Application no: 22/02693/DISC

Location: Heyford Park, Camp Road, Upper Heyford, Bicester, OX25 5HD

Lead Local Flood Authority

Recommendation:

**DETAILS**  
PHASE 10  
ENGINEERING LAYOUT SHEET 1 OF 3

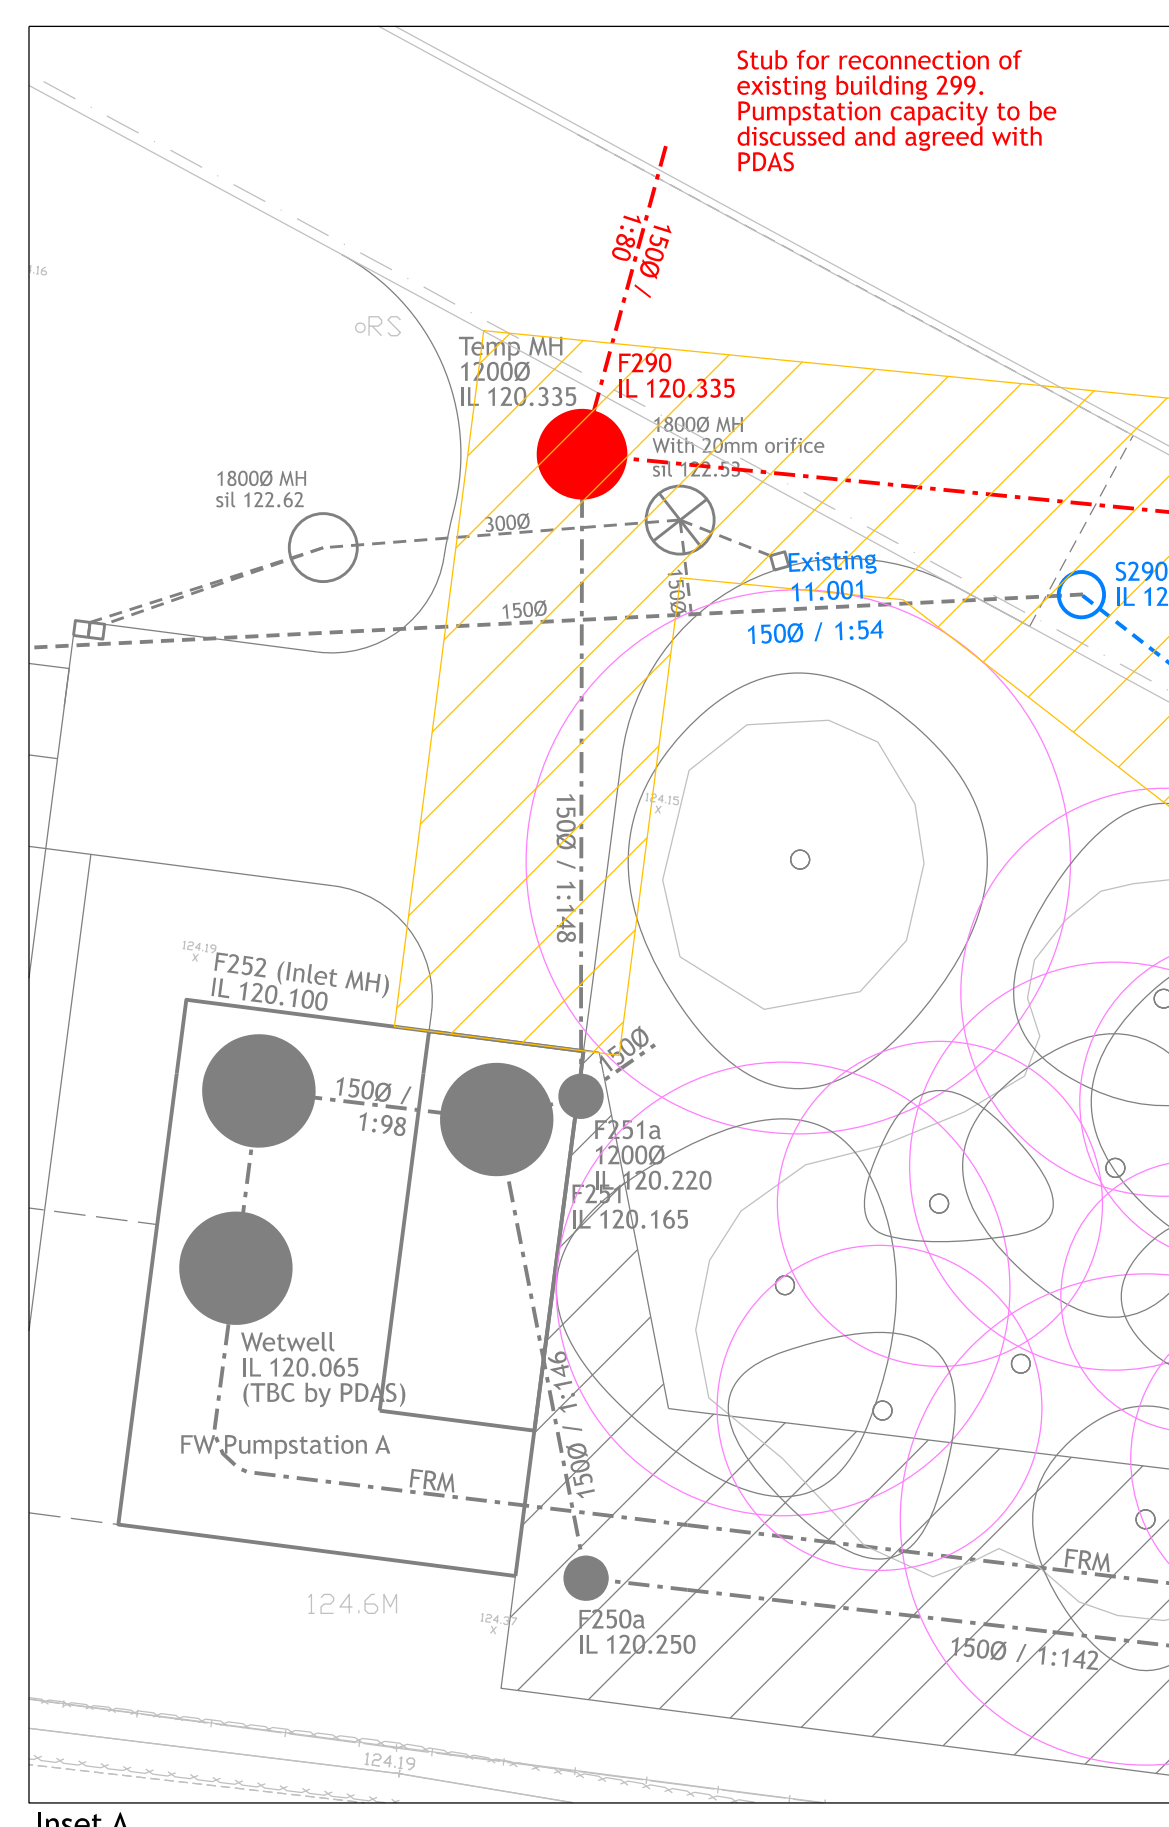
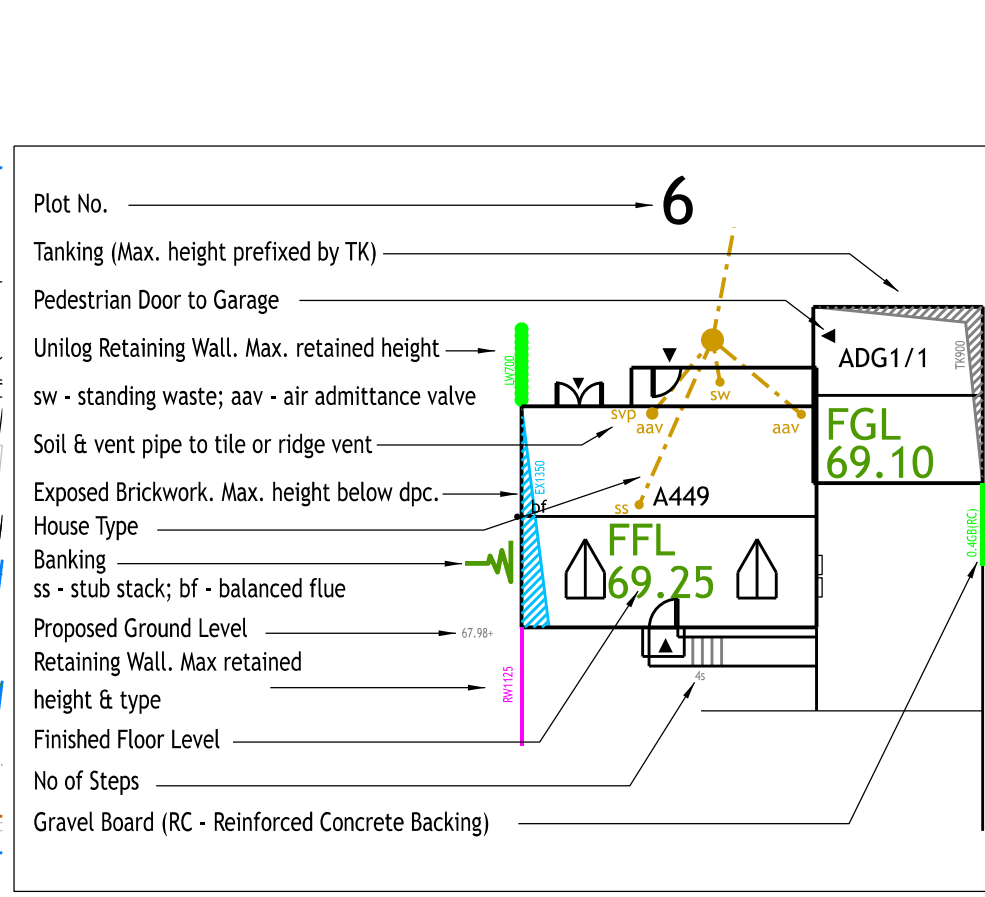
Permeable paving not considered considered as a form of treatment for the parking areas. Phase 10 boundary not included on the drainage drawing. Private areas proposed drainage needs to be shown.

Provide surface water catchment plan clearly showing the extent of the impermeable areas and stating the area. Also state the area with 10% urban creep.

Provide phase boundary.

Cover levels are not shown for the drainage infrastructure.
